# RE : Dart + West+ Project . Reference 314232 . Interested Party not notified and excluded from process.

My Name is Cathleen Herbert and I wish lodge an objection and make observations in relation to the planning application submitted by Dart + West for planning permission for new Railway lines and Depot located between Maynooth & Kilcock. The project in its current form (your application reference 314232) is unacceptable and the application is invalid in so far as it has failed to adhere to the most basic planning regulation and furthermore I want to formally make a request for an Oral hearing.

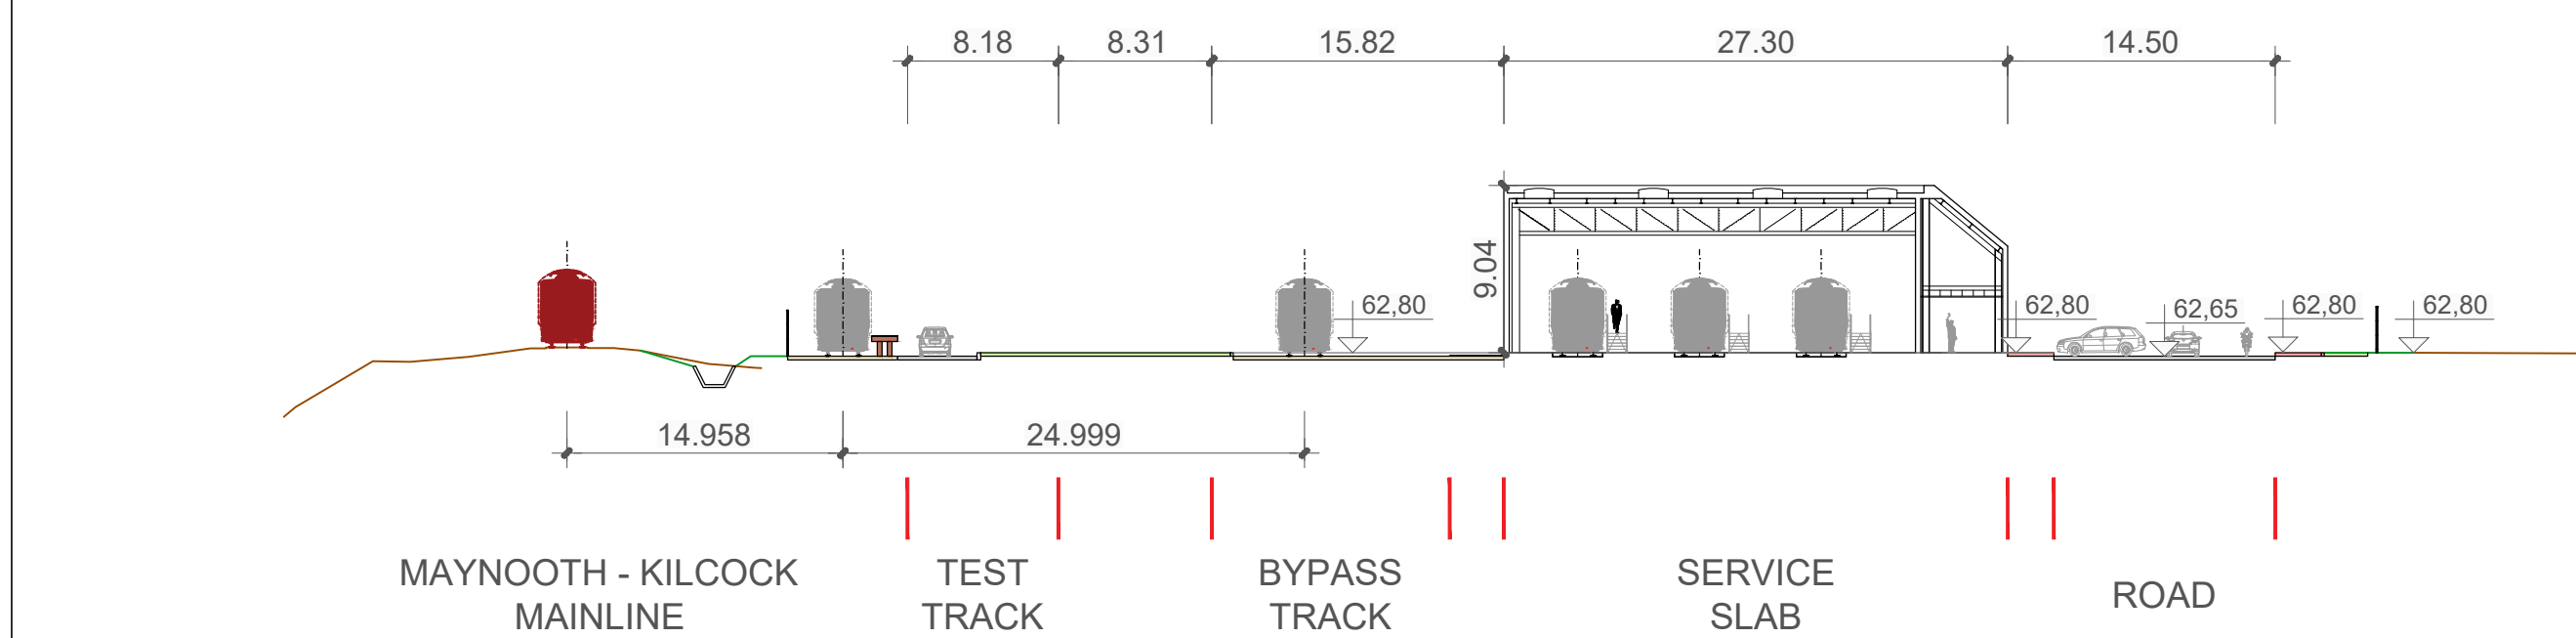
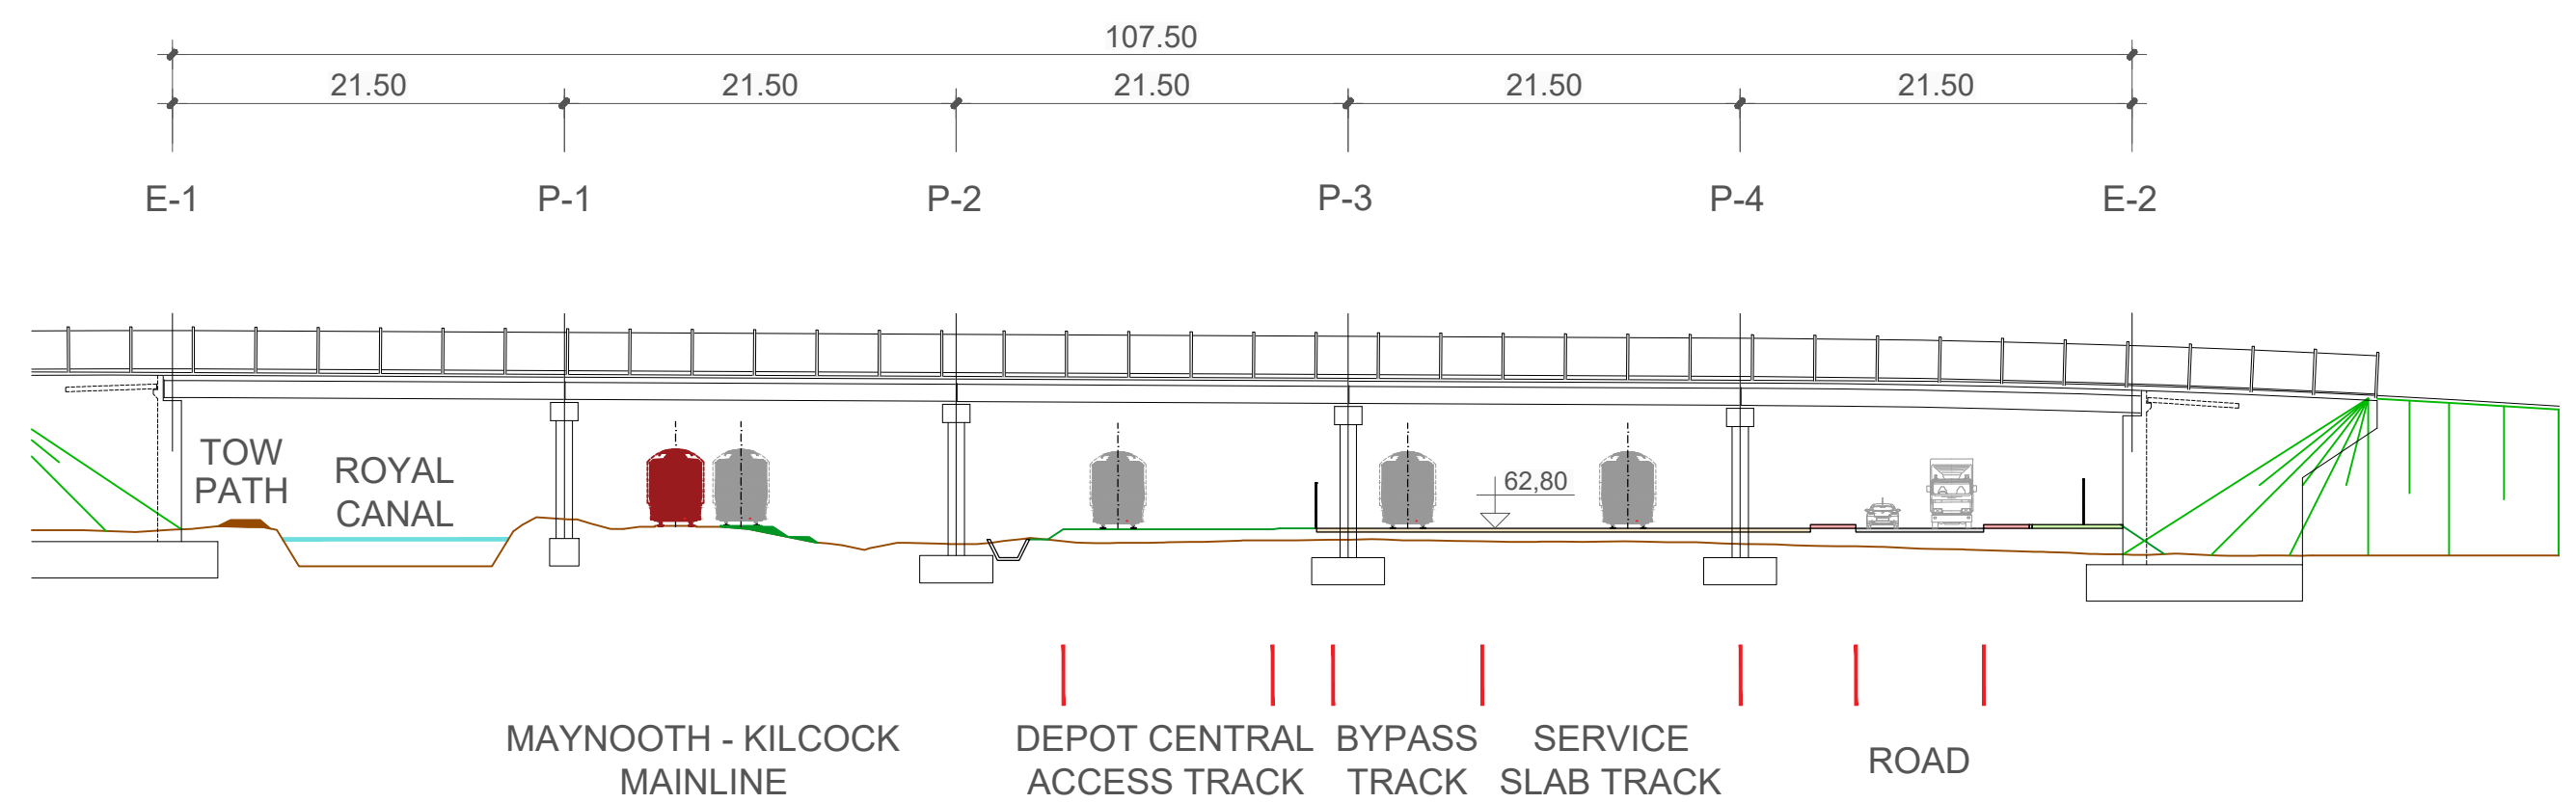
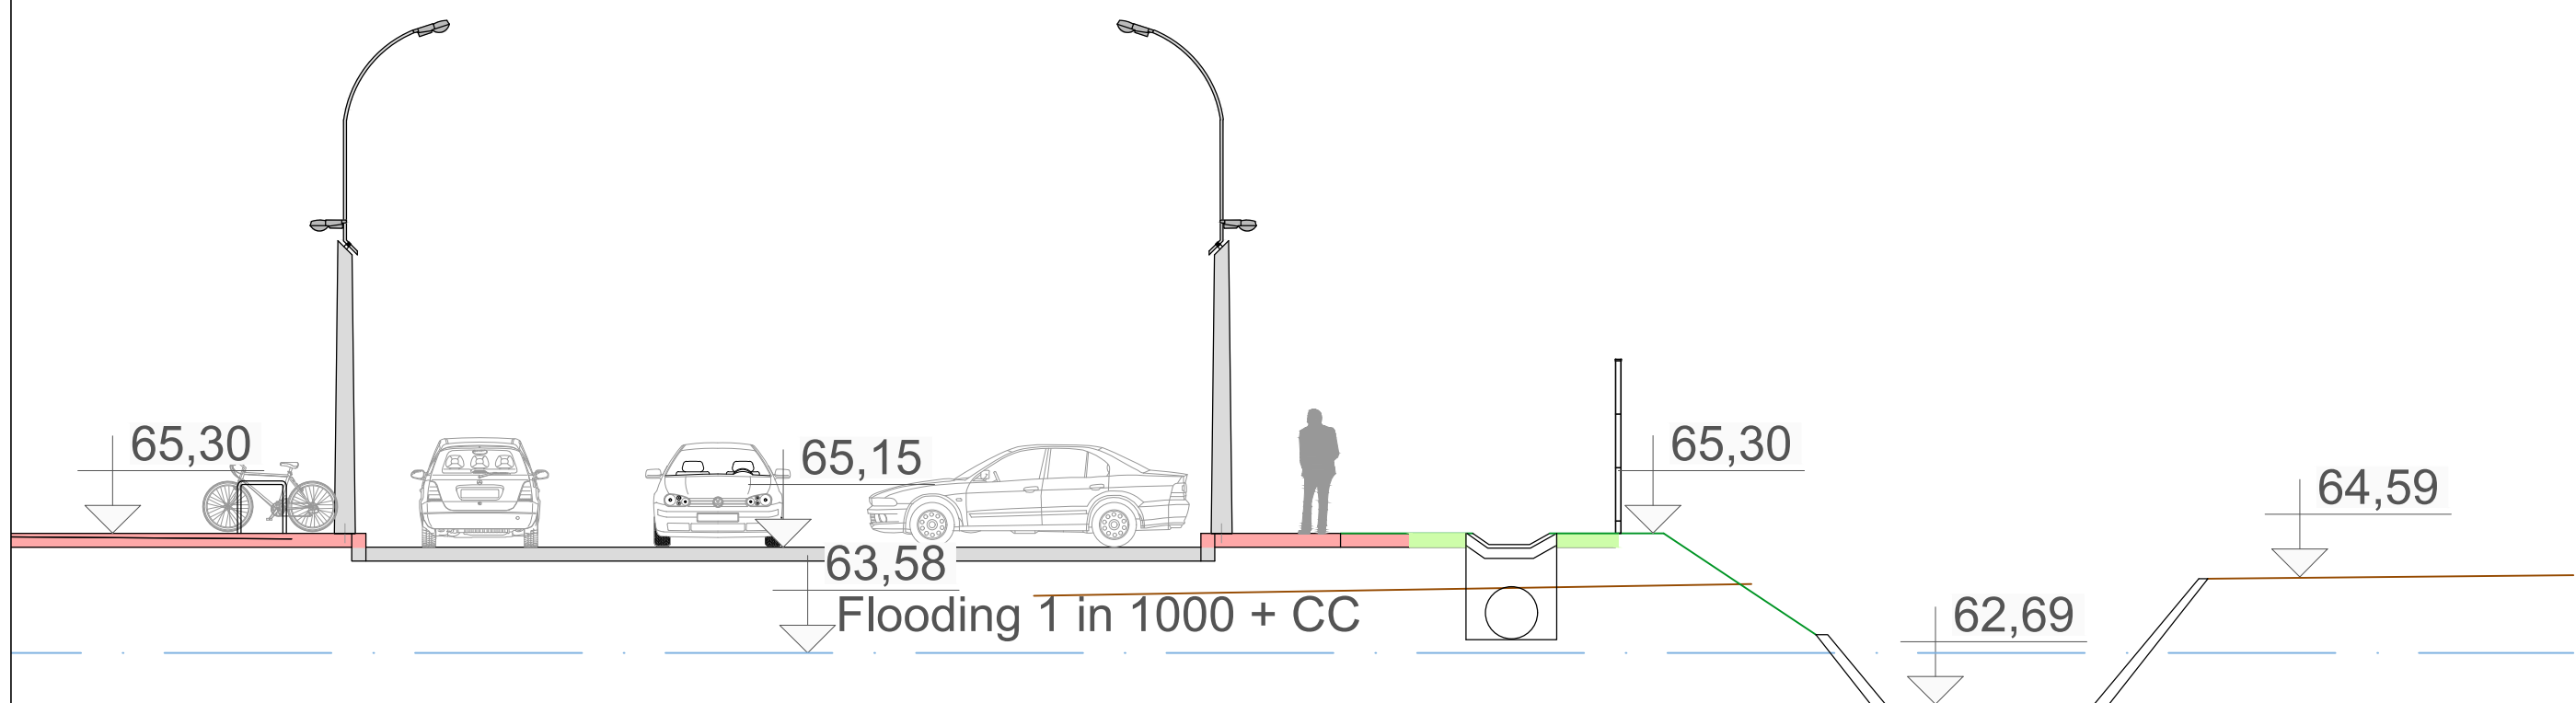
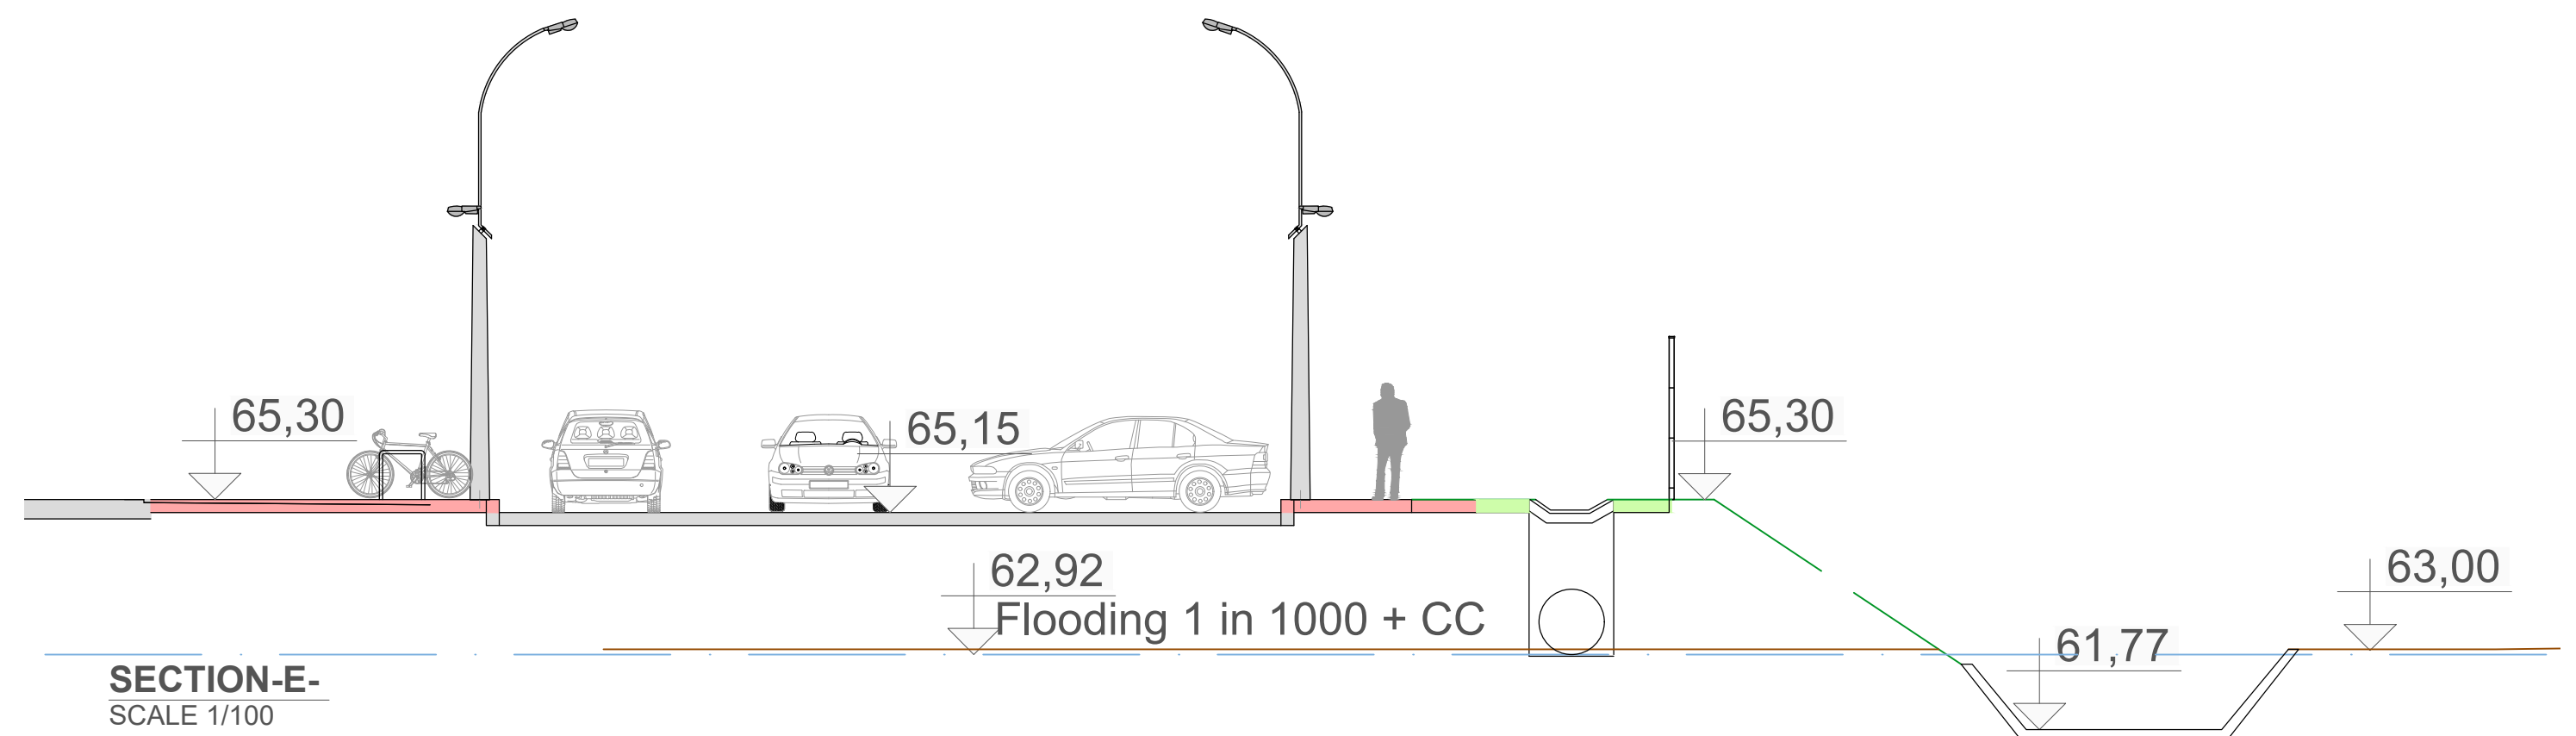
The drawing for depot are not properly complete and doesn't include proper levels . It is not possible to compare the levels of the new works as compared with the existing levels of the surround countryside
